EXPLANATORY ADDENDUM

Issue date: 27 November 2019
Issued by: Alex Lohrisch
Client: Goodman Property Services (Aust) Pty Ltd
Reference: MEM002-01-15-272-Mod Report Explanatory Addendum.docx
Subject: SSDA 7348 EXPLANATORY ADDENDUM TO MOD 2 CIVIL ENGINEERING REPORT (REV 11 SEPT 2019)

Purpose This Explanatory Addendum is to respond directly to the Environmental Assessment Requirements (EARs) issued by DPIE on 15 NOV 2019. Additionally, this Explanatory Addendum is to concisely describe the amendments made to the previous Civil, Stormwater and Infrastructure Services Report (MOD 1, REV 10 AUG 2019), as a result of the changes proposed to SSDA 7348 Modification No. 2 (REV 11 SEPT 2019).

Figure 8 – Precinct 1 Modified Layout

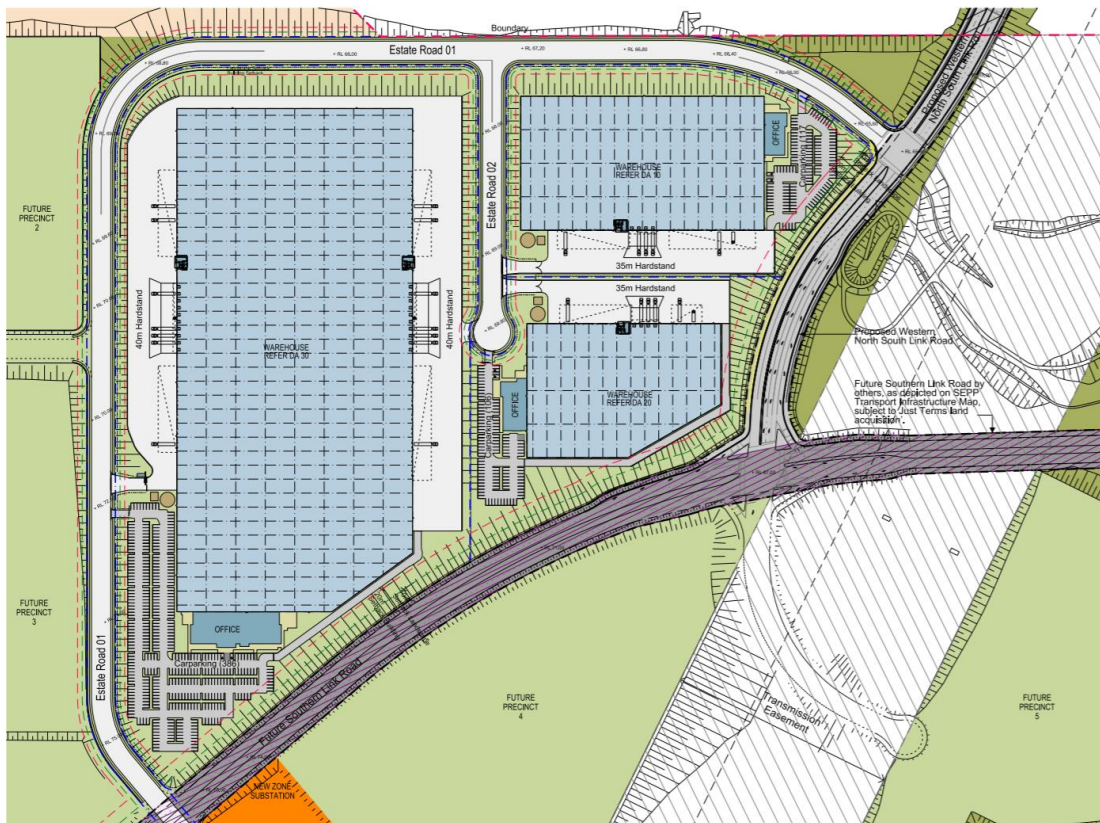
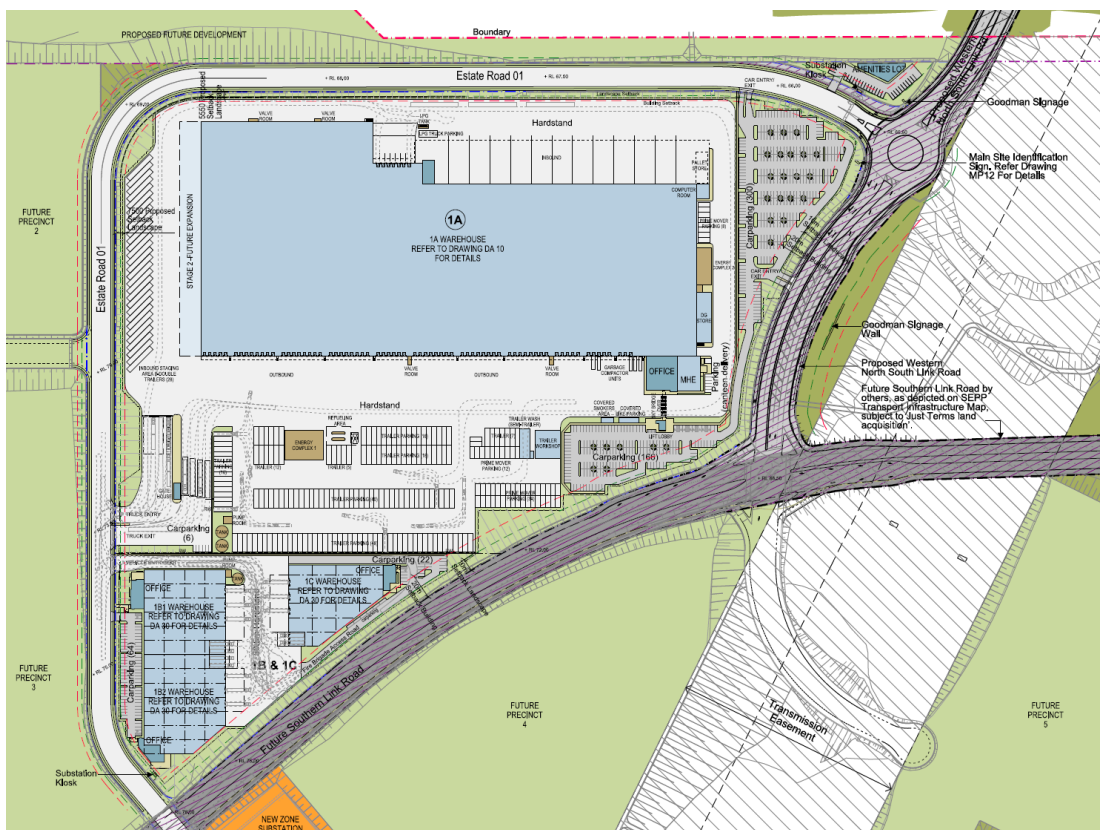
Precinct 1 has been modified to suit the revised on-lot building layout, which includes the removal of Road 2.
